Consultee Comments for Planning Application

SDNP/24/01292/FUL

Address: The Oaks 35 St Marys Road Liss Hampshire GU33 7AH

Proposal: Detached dwelling

Client  
**The Oaks**  
 Address  
 35 St Mary's Road  
 Liss  
 GU33 7AH  
 Drawing title  
 Acornis  
 Proposed Elevations

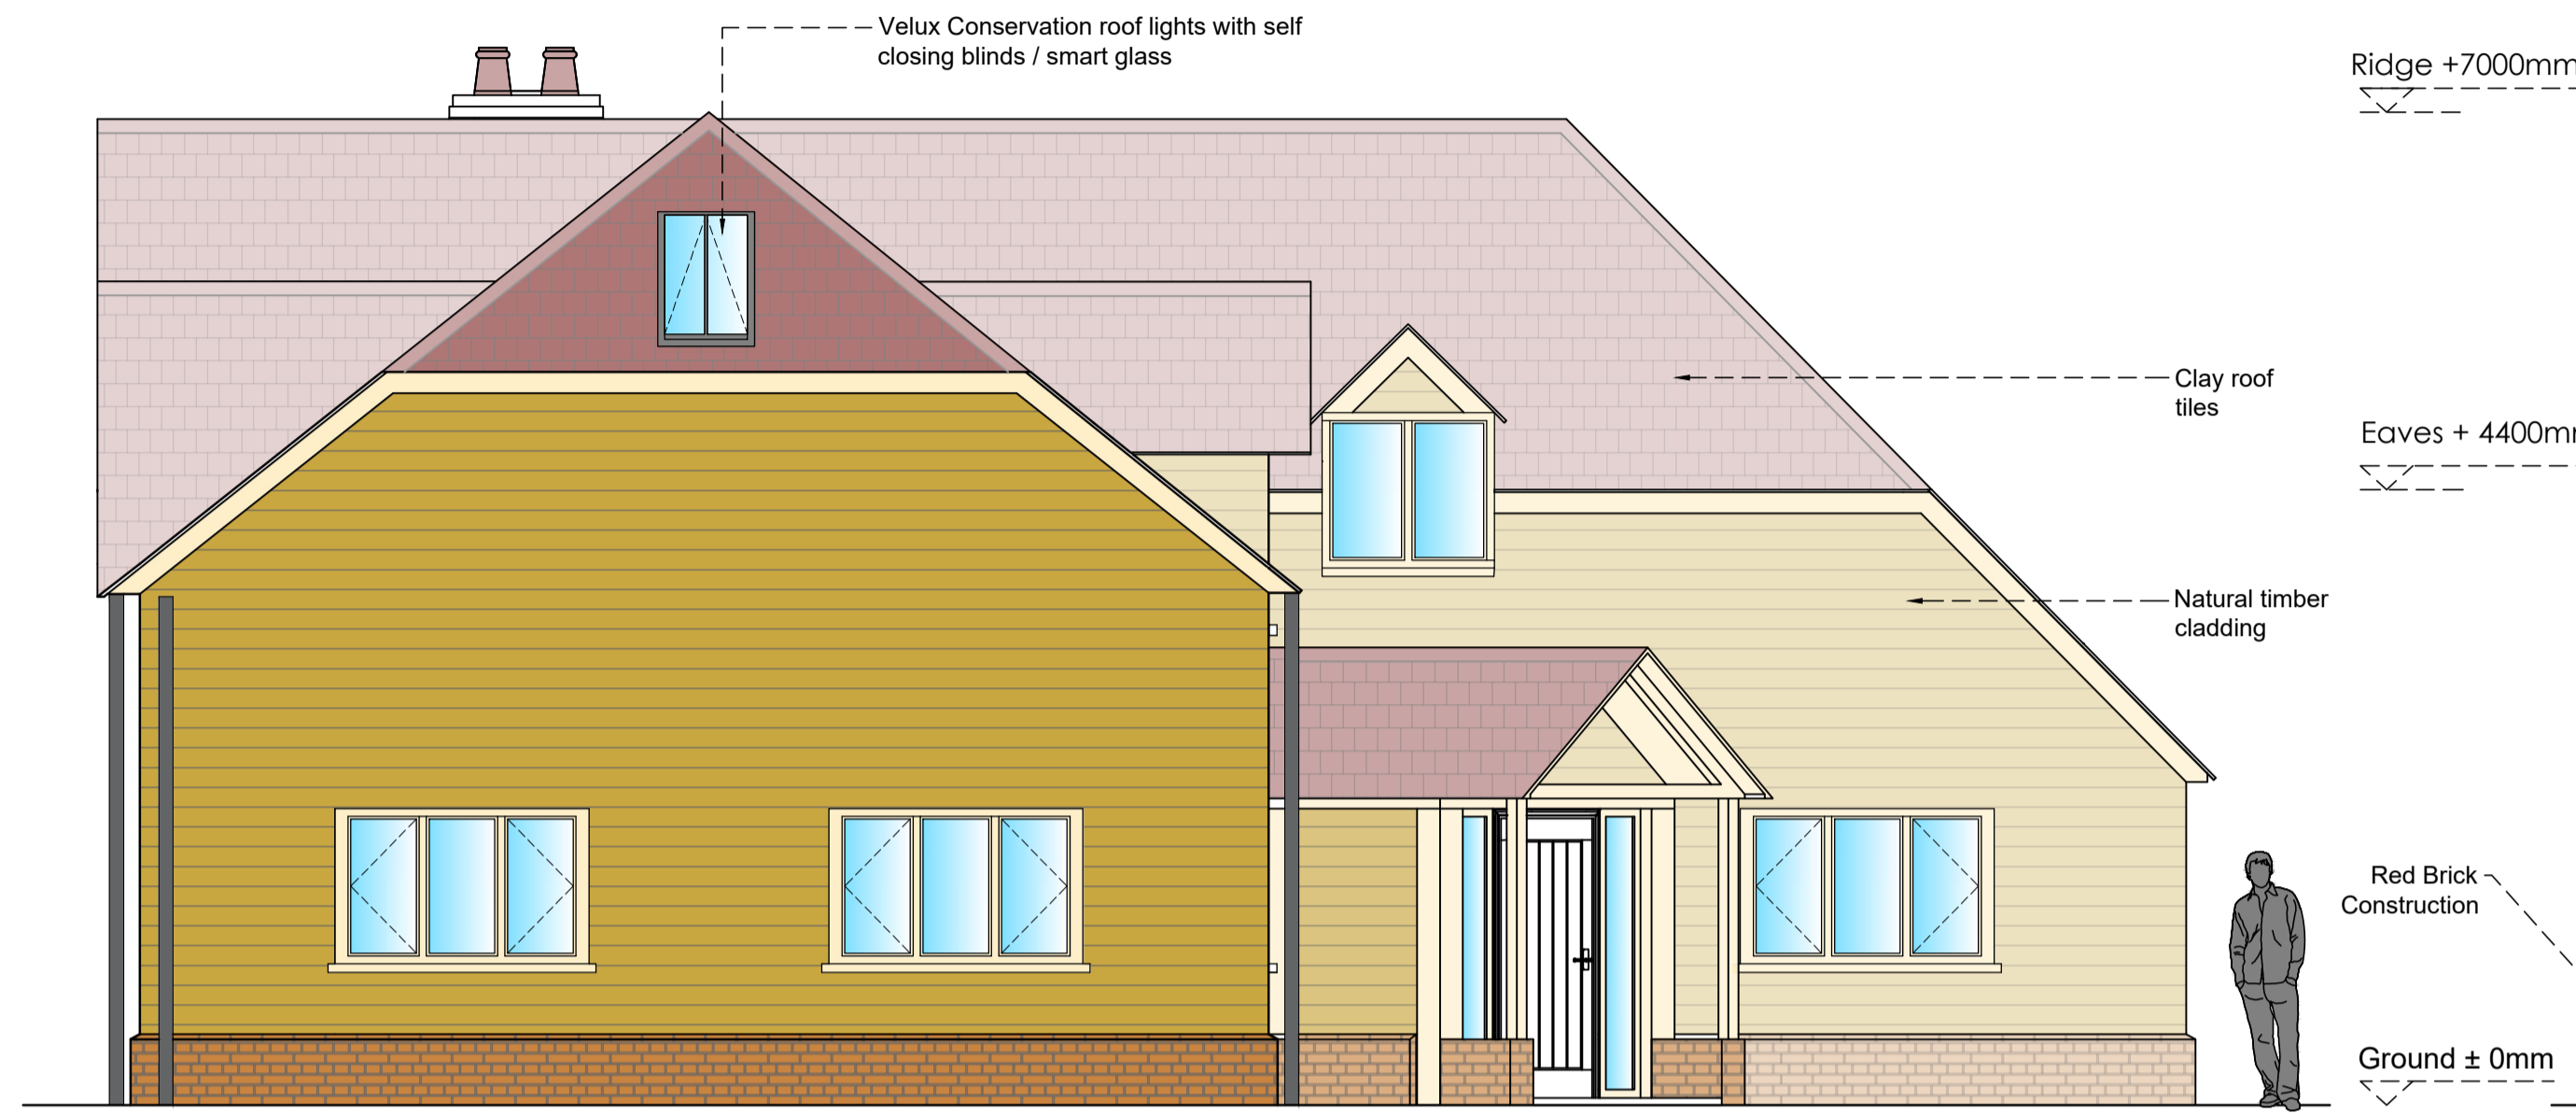
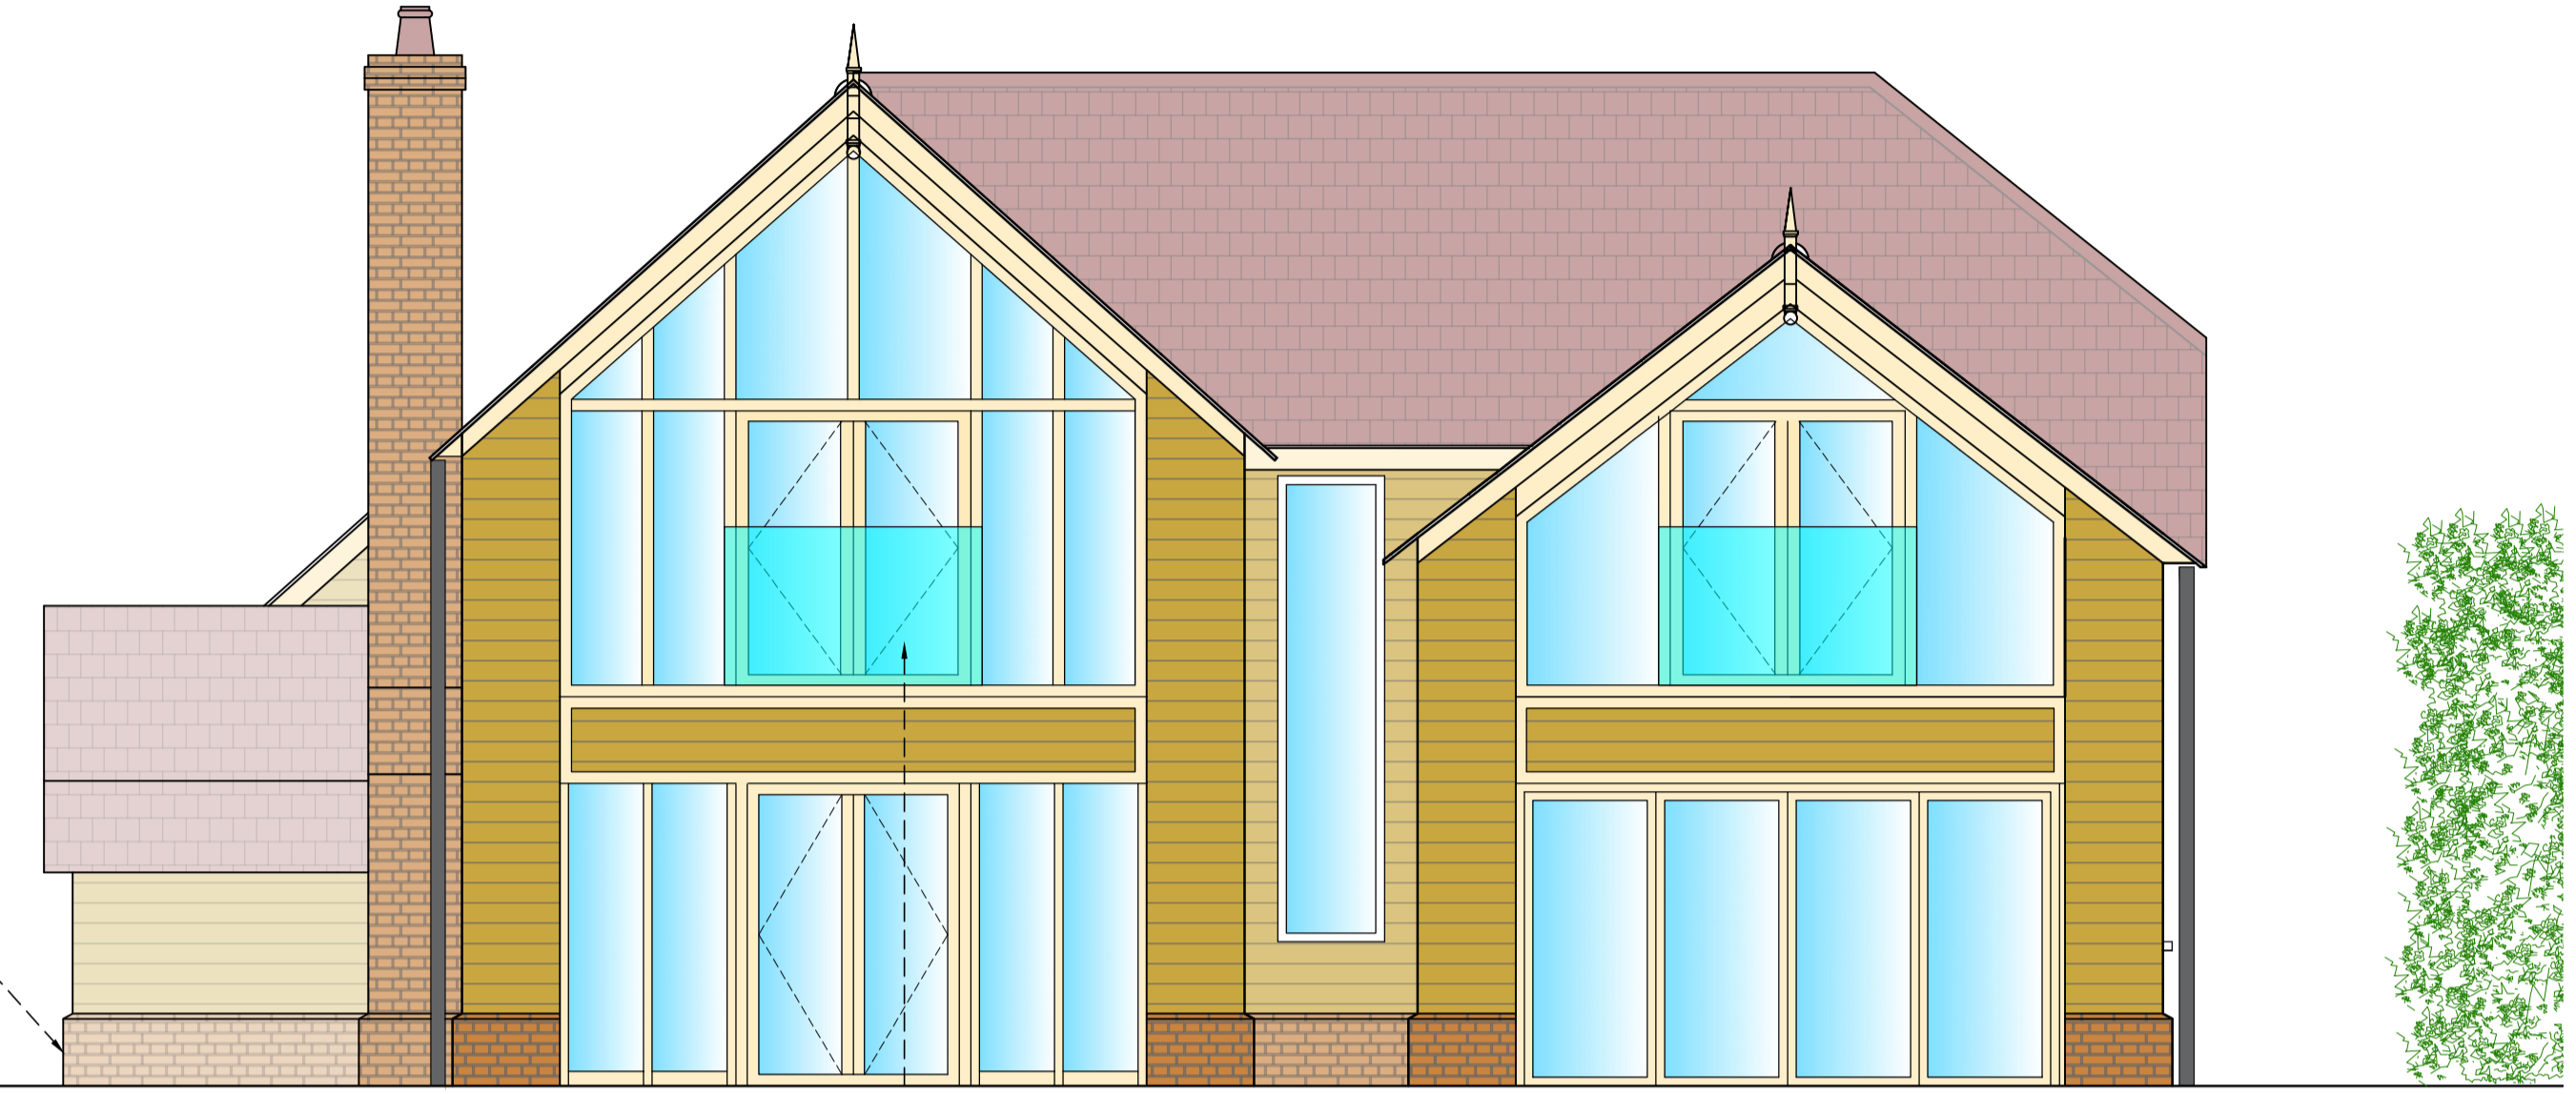
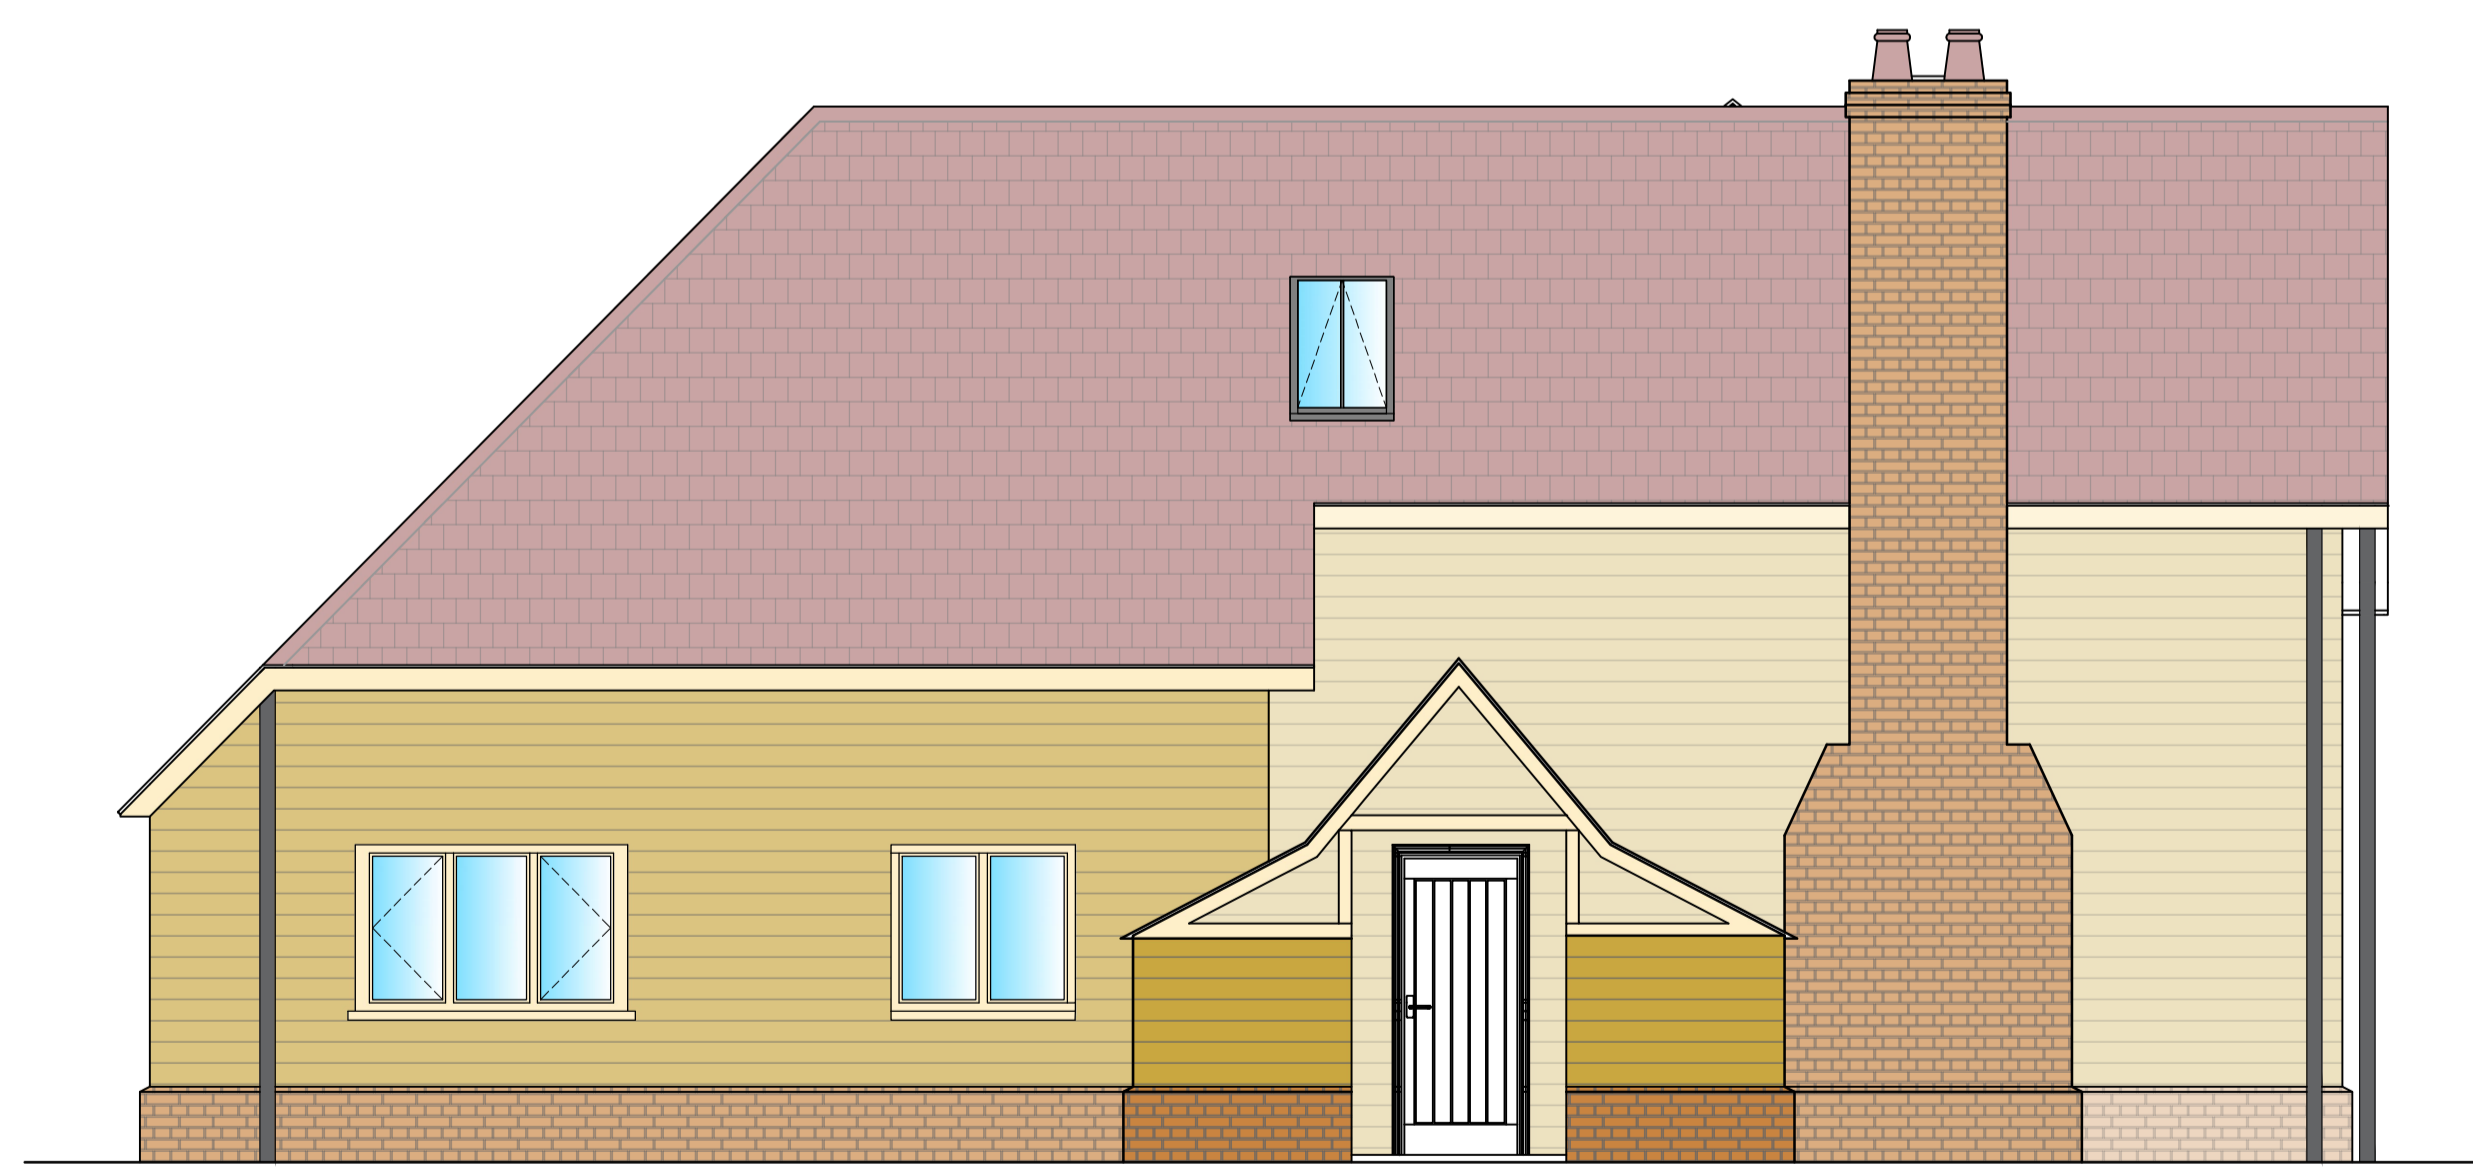
I welcome the statement about ASHP and PV panels but I cannot see them on the elevations.
